Appendix A - Response to Submissions Table

SOUTH ELEVATION. (BURDETT ST).

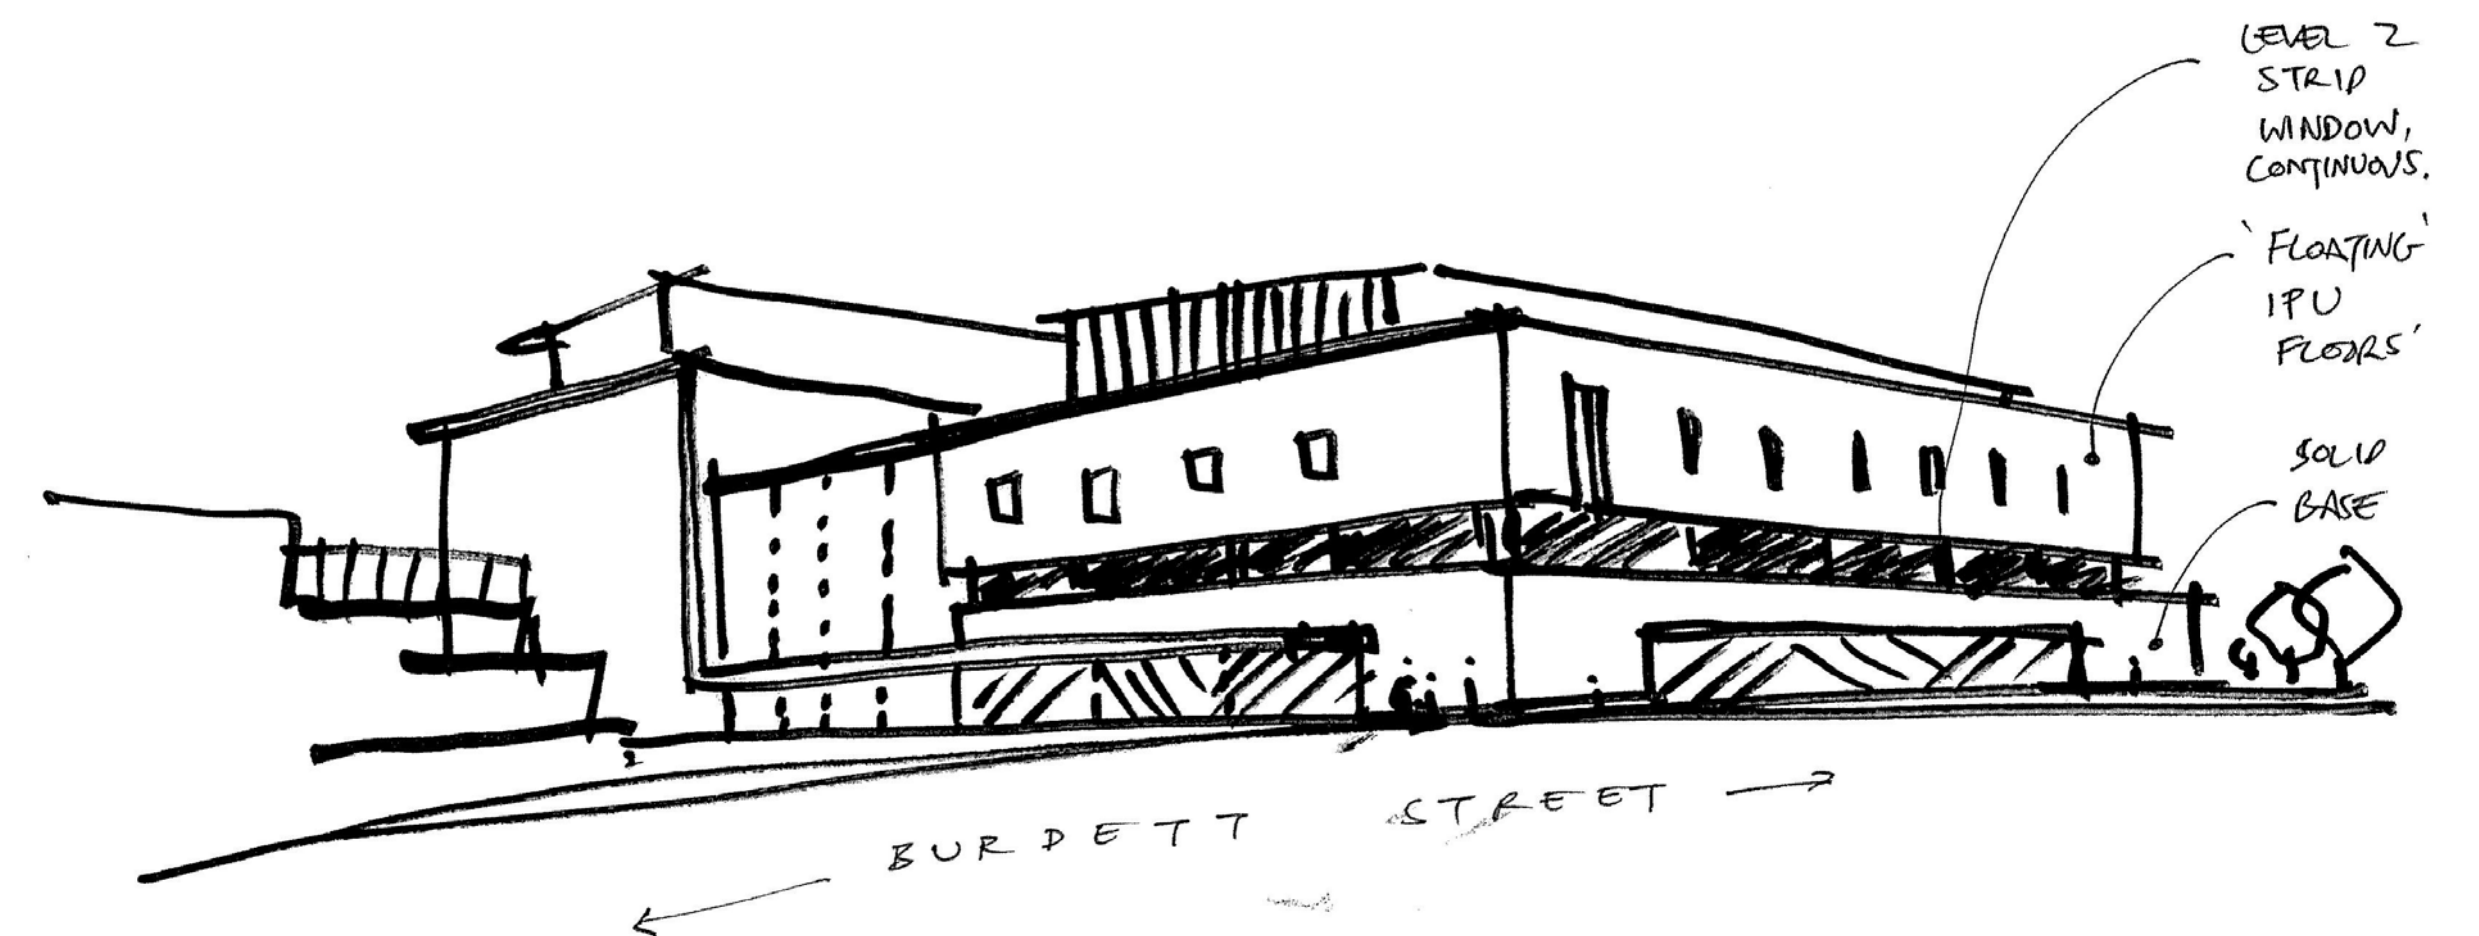
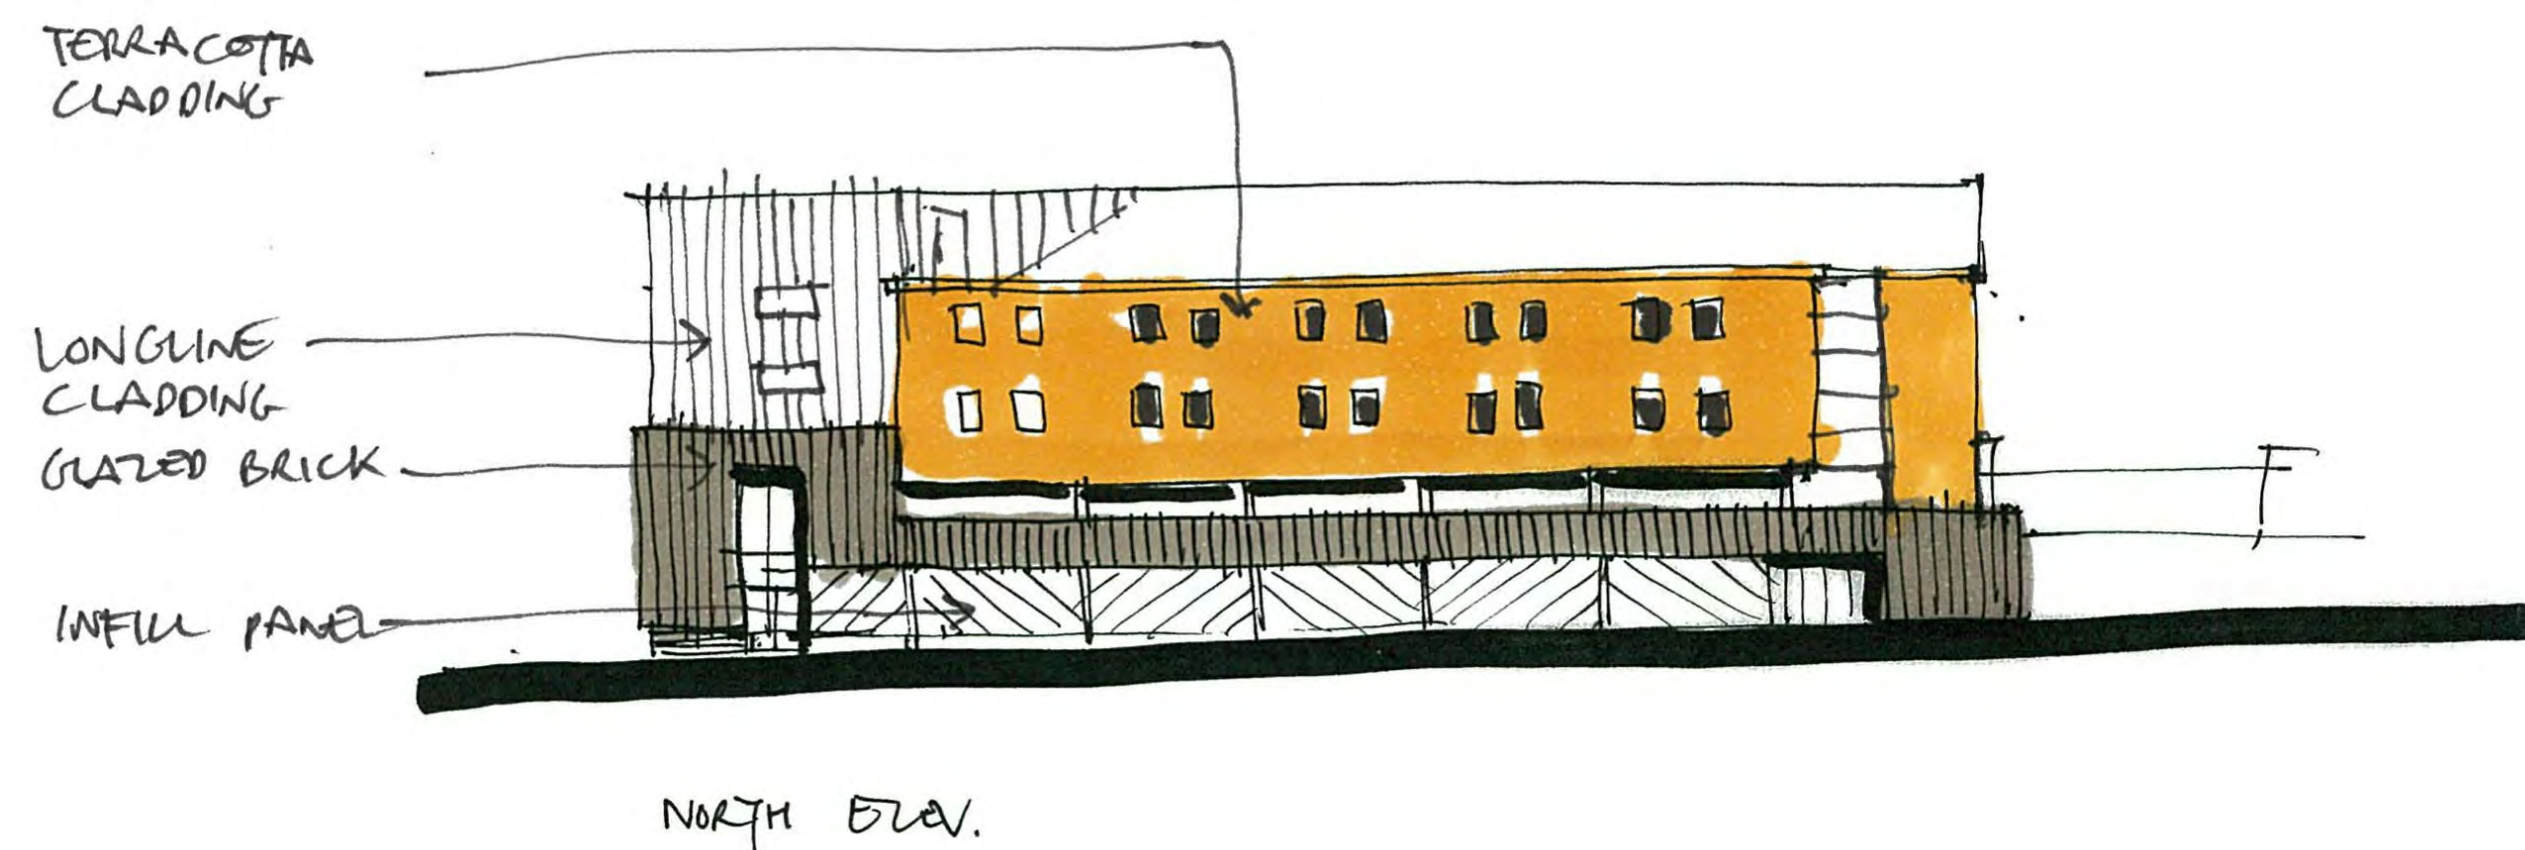
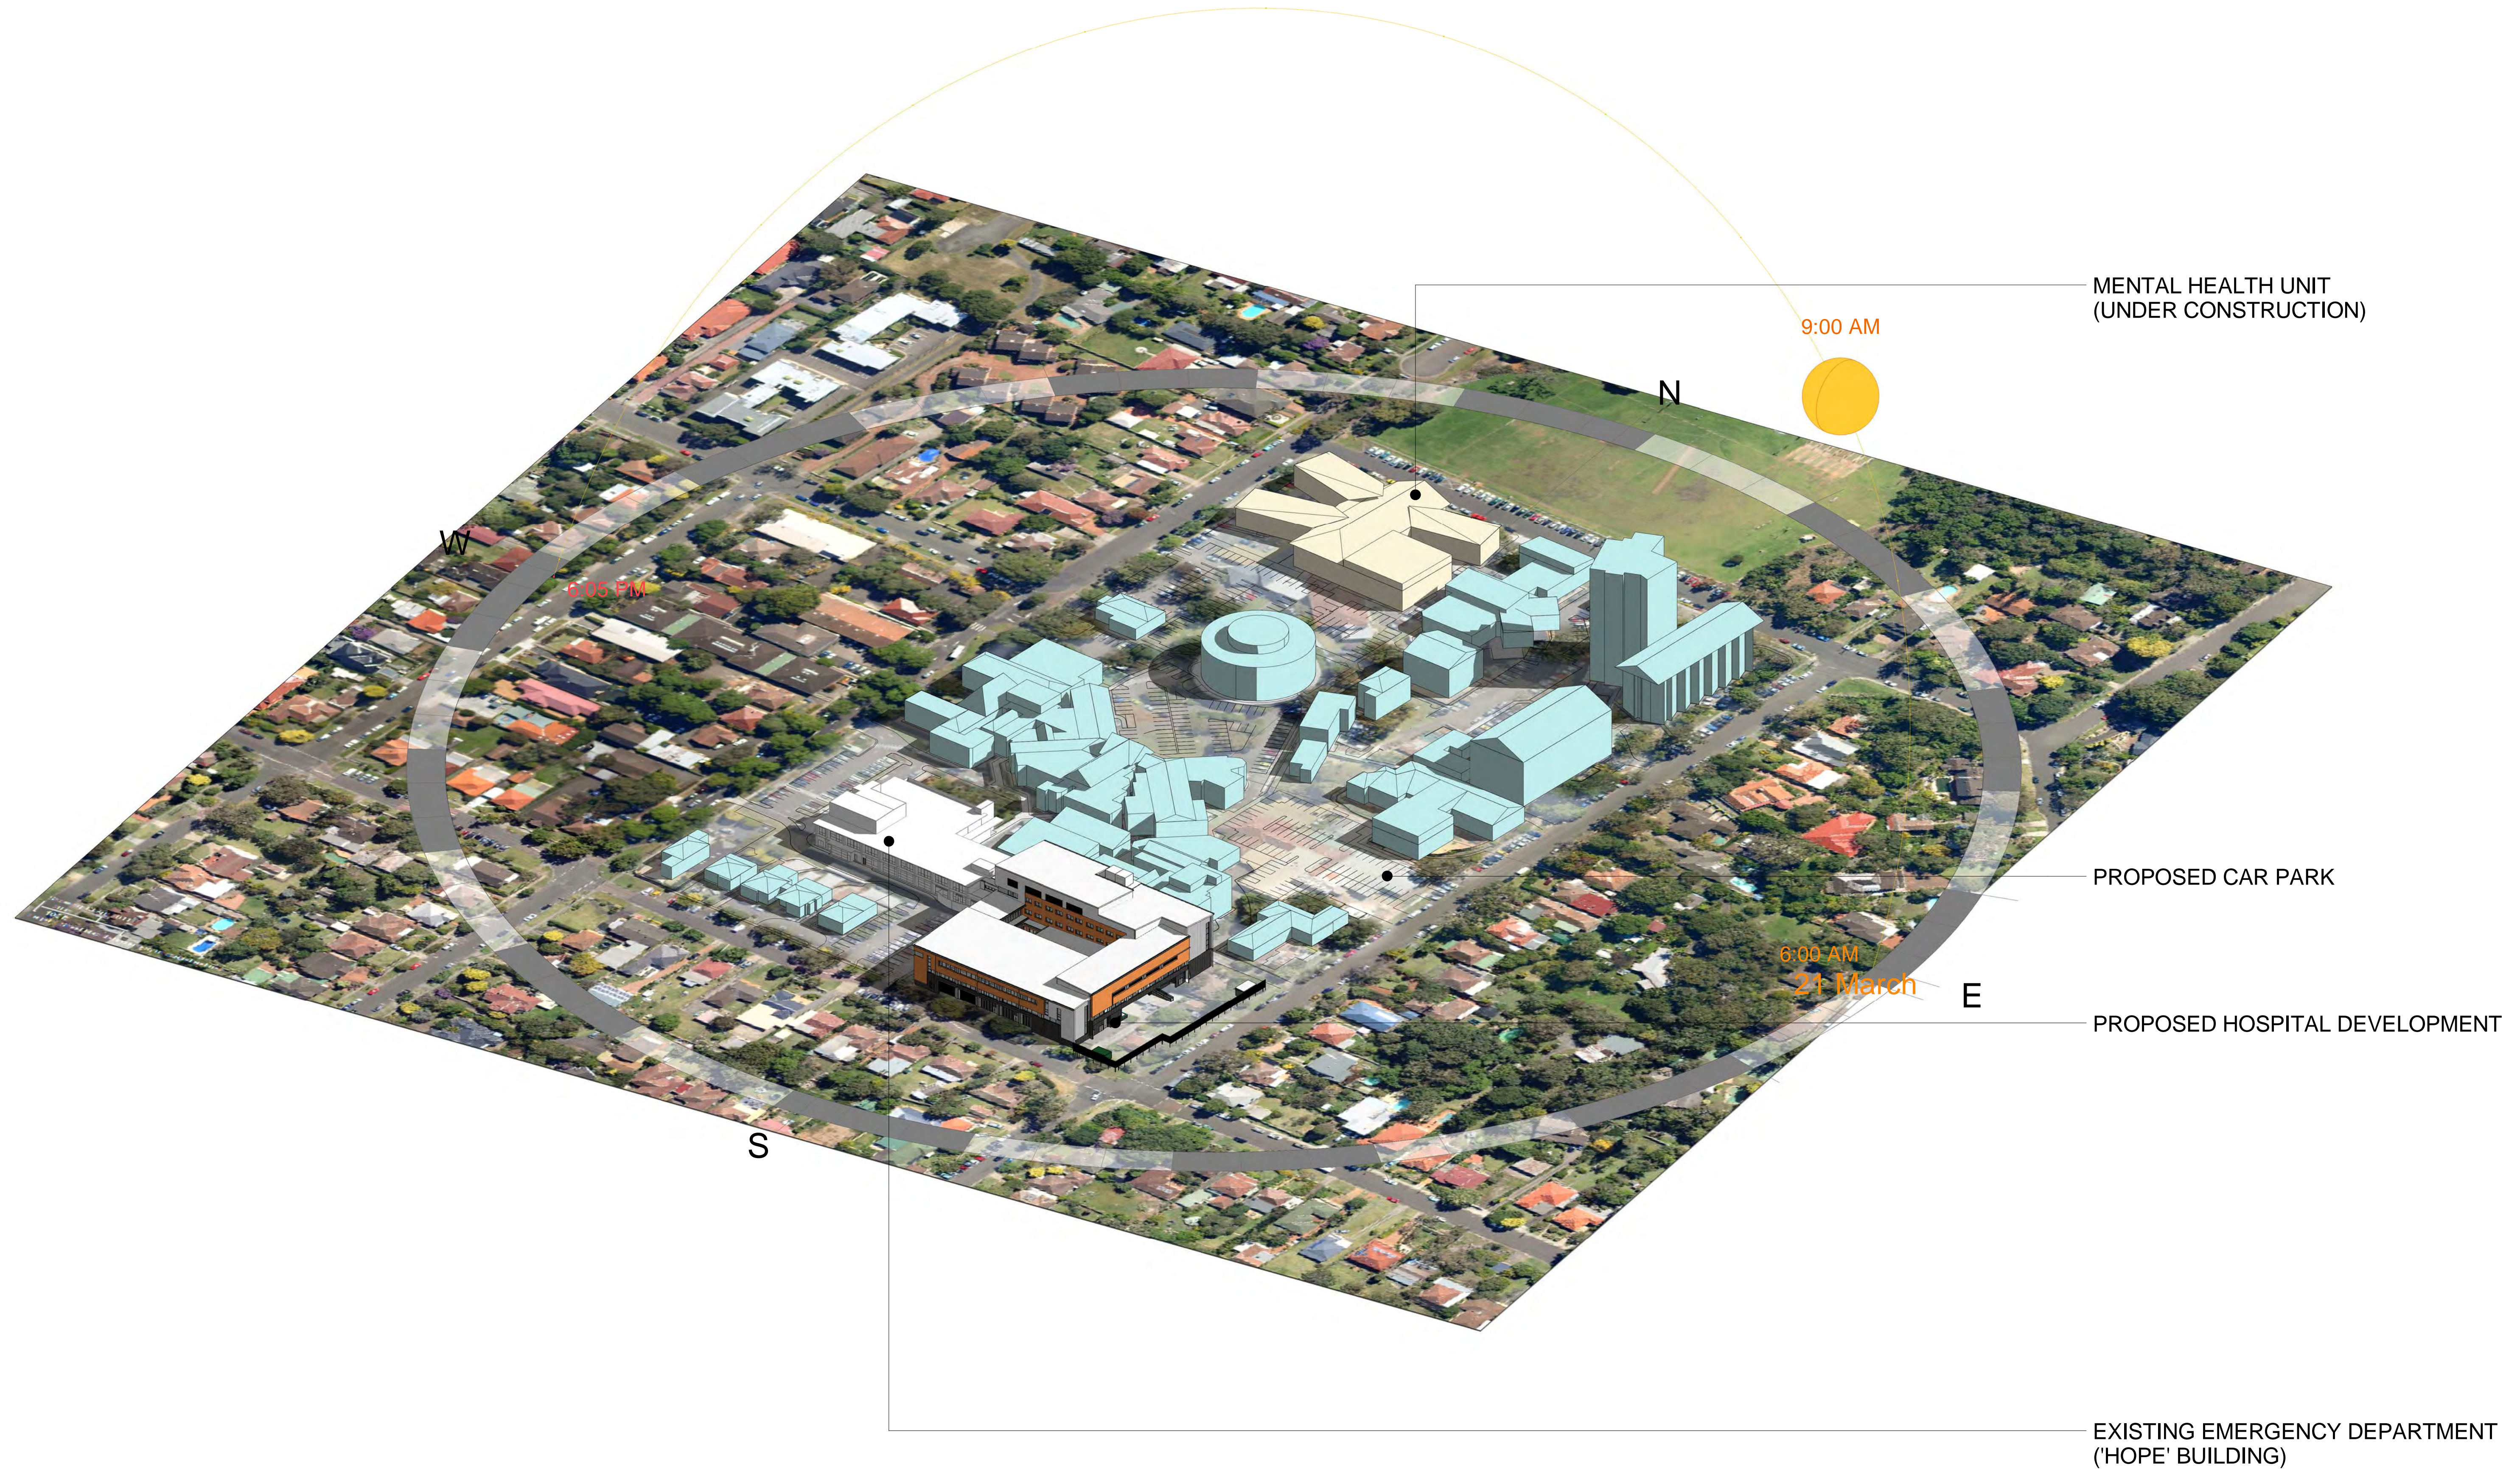
Issues Raised	Proponent's Response
Agency Submissions	
<p>Hornsby Shire Council</p>	<p>Council's concerns in relation to the proposal are as follows:</p> <p><u>Planning</u></p> <p>Hornsby LEP 1994 does not provide a maximum FSR in Special A zone, however Council's Community Uses DCP requires development in Special A zone not to exceed 0.4:1 adjoining low density areas.</p> <p>Council requests that the Department be satisfied the bulk, scale and intensity of development would be compatible with the surrounding low density areas.</p> <hr/> <p><u>Height</u></p> <p>Council requests the Department in its assessment of the proposal has regard to the existing streetscape character to ensure the building would not unreasonably restrict sunlight or result in loss of privacy and amenity to adjacent residential properties.</p>

Issues Raised	Proponent's Response
<ul style="list-style-type: none"> ▪ The colour scheme will become dated. The metal cladding is not acceptable. Colorbond is also not acceptable as it is only guaranteed for 25 yrs. 	<p>As above, the material selection and colours have been chosen to provide a light weight and modern building design that will achieve design excellence and material longevity.</p> <p>The design principles employed ensure the building is in context with neighbouring buildings.</p>
<ul style="list-style-type: none"> ▪ The external loading dock will make Derby Road look like an industrial site. The Westfield has internal loading docks which should also apply to the hospital. 	<p>The development utilises the existing entry and exit points off Derby Road. This will minimise any unnecessary disruption to the current operation of the hospital. Indeed, redundant access points will be removed.</p> <p>The Westfields Shopping Centre is located within the Hornsby CBD and cannot readily be compared to the Hospital redevelopment. The Hospital has limited space and differing handling requirements to that of a shopping centre. The building takes advantage of the sloping grades in this location to provide a substantial undercroft area, which also avoids costly excavation (and the likely extended noise impacts during construction).</p>

Issues Raised	Proponent's Response
	<p>windows to principal internal daytime living spaces between 9am and 3pm.</p> <p>The addition of vegetation within the setback will (when mature) provide further privacy screening and softening buffering. Further, as described in Section 2.2 of the Response to Submission Report, the proposed development's envelope and scale is appropriate in relation to the width of Burdett Street. Figure 3 of the Response to Submission Report demonstrates the containment of the building wholly within the sightline of 45° when an individual is viewing the development from the opposite side of Burdett Street. The proposal is therefore not considered to be overbearing and bulky from street level and is appropriate in its context and relative to the lack of height controls governing development of the site.</p>
<p><u>Setback and Landscape</u></p> <p>The building setback to Burdett Street should be increased to enable additional landscaping within the site between the building and the property boundary along the frontage.</p> <p>There is limited articulation of the building façade and the setback should be consistent with the existing established streetscape.</p> <p>Small trees should be provided in the additional landscape area between building and property boundary.</p>	<p>The landscape setback to Burdett Street has been increased by reducing the width of the maintenance path that runs along the southern boundary of the building. This allows for additional planting between the property boundary along the Burdett Street frontage.</p> <p>There are no site-specific provisions for setbacks within Hornsby Shire Council's controls. Therefore the setback has been considered on its merits and is considered suitable for the scale of the proposed building, consistent with the existing hospital development.</p> <p>As detailed in Section 2.2 of the Response to Submission Report, the Stage 1 footprint has been located to provide for optimal functional adjacency and connectivity to the HOPE building and to minimise disruption to ongoing hospital-related activities and to provide for the best continuity of services to the community. Its location also allows for only minimal removal of vegetation and takes advantage of existing driveway crossings. Furthermore, and most importantly, the floor plate is designed to deliver optimal functional and efficient health services. There is no flexibility for the building to</p>

Issues Raised	Proponent's Response
	<p>of the Burdett Street frontage. Open areas and activity at the car park and site entrance to the building provide suitable passive security and activity in this location at Burdett Street. The corner treatment of Burdett Street and Derby Road at the site's boundary has been revised to allow for clear sight-lines around the corner. This is achieved through a splayed / chamfered edge to the fence and landscaping in this location. As for the Burdett Street frontage, the Derby Road frontage to the hospital (to its loading dock area) has been screened to provide a higher amenity outcome from a visual and acoustic perspective. On balance a suitable design and 'safer by design' outcome has resulted that addresses a range of planning issues.</p>
<ul style="list-style-type: none"> ▪ The minimal setback will provide an inadequate amount of landscaping that might assist to ameliorate the excessive height and scale of building. 	<p>Additional landscaping has been designed by Arcadia (see Appendix D to the main Response to Submissions Report). Arcadia has specified plantings to assist in providing a softened edge to and within the Burdett Street setback zone. Refer also to Section 2.2 of the Response to Submission Report for further detail.</p>
